RE: DRAINAGE PLAN FOR WHALE OF A WASH  
@ WYOMING (H-19/D46)

RE: DRAINAGE PLAN FOR WHALE OF A WASH @ WYOMING  
(H-19/D46) RECEIVED OCTOBER 21, 1987

RE: REVISED DRAINAGE PLAN FOR WHALE OF A WASH AT WYOMING (H19-D46) REVISION  
DATED 11/13/87

## GRADING & DRAINAGE PLAN - WYOMING SITE

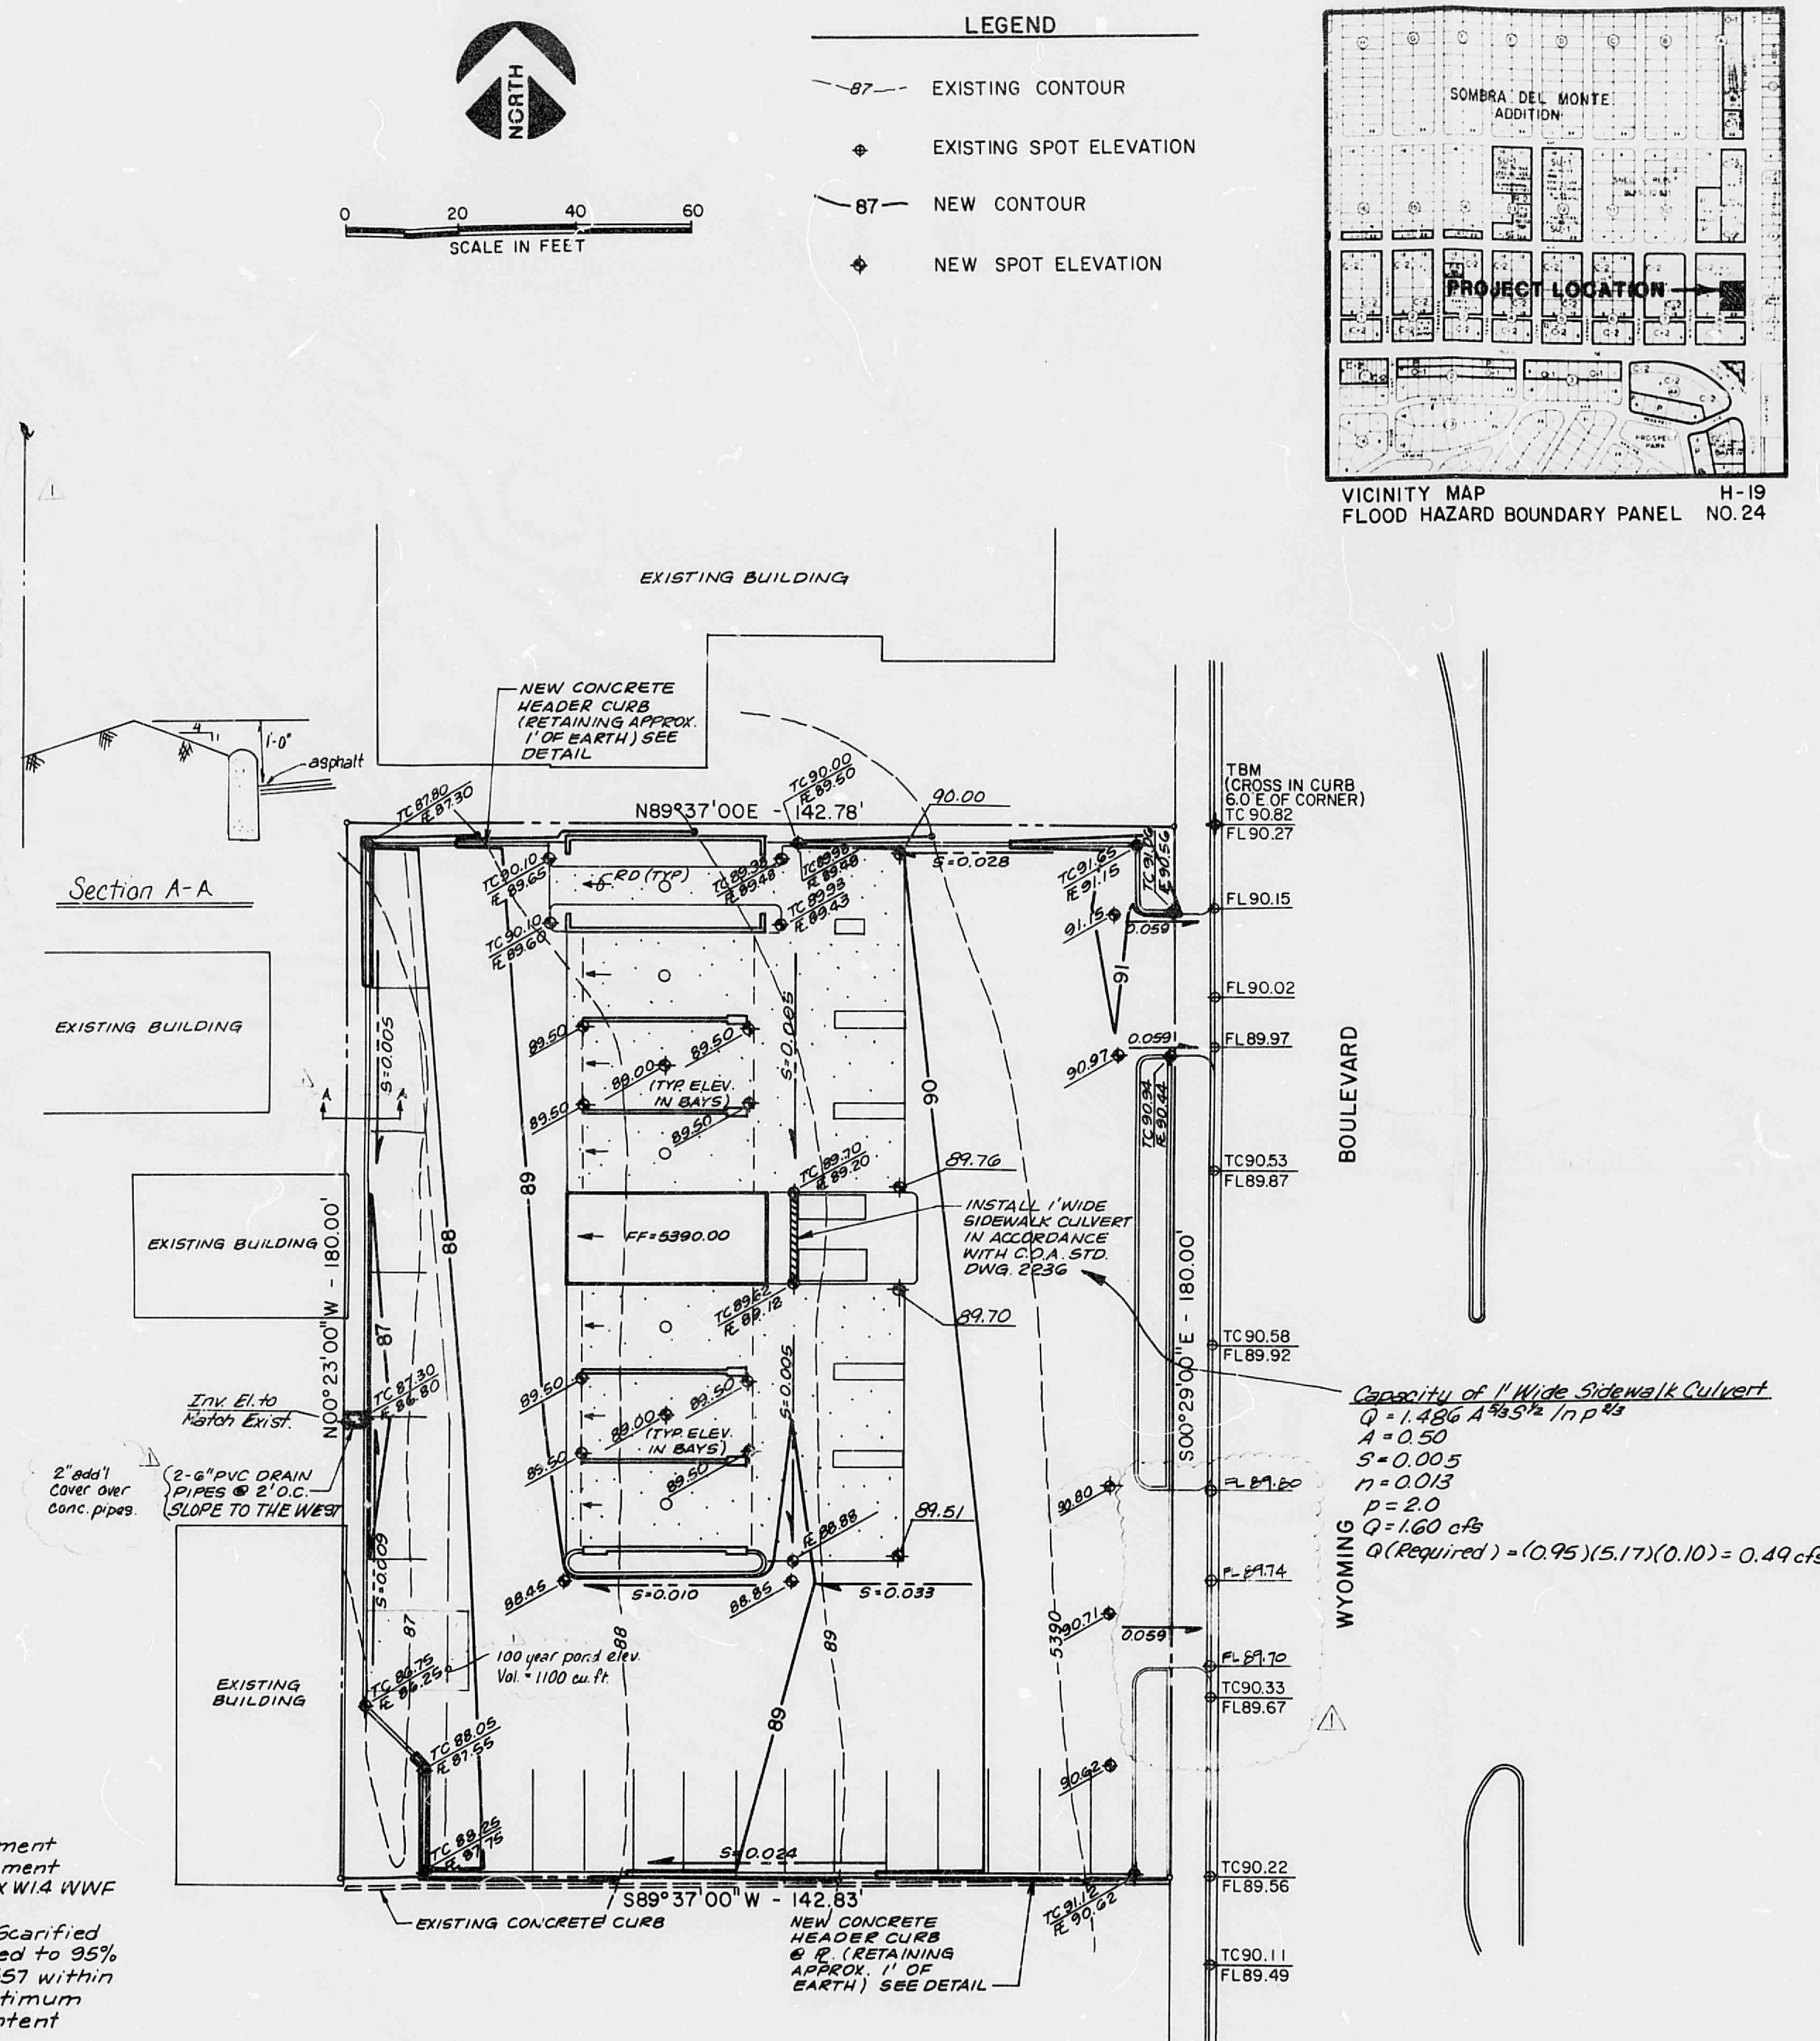
1. You will need to increase the height of your proposed curb along the west property line to contain the ponded portion of runoff and also to have sufficient cover over the proposed 6" PVC.
2. Please indicate your 100 year pond elevation on the plan drawing.
3. Please elaborate on what effect the runoff will have on the existing developments to the west. Flooding potential must be addressed.
4. Unable to follow where you obtain controlled release of .52 cfs.

1. The curb along the west property line will be increase to 8" at the locations of the 6" PVC pipes. A 6 inch high berm will be added along the landscape strip to control the volume of pond required, see the attached calculations sheet.
2. The 100 year pond elevation has been added to the plan.
3. The area is not in a 100-year flood zone and will not flood the property to the west. The development proposed will improve existing runoff conditions to the west. Currently runoff randomly crosses the west property line towards existing buildings. The proposed development will eliminate the "random" runoff and discharge it at a controlled point between two existing building. The runoff volume and rate will also be decreased due to the development.
4. The controlled release of 0.52 was an error, the actual controlled release will be  $2.68 - 1.33 = 1.35$  cfs.
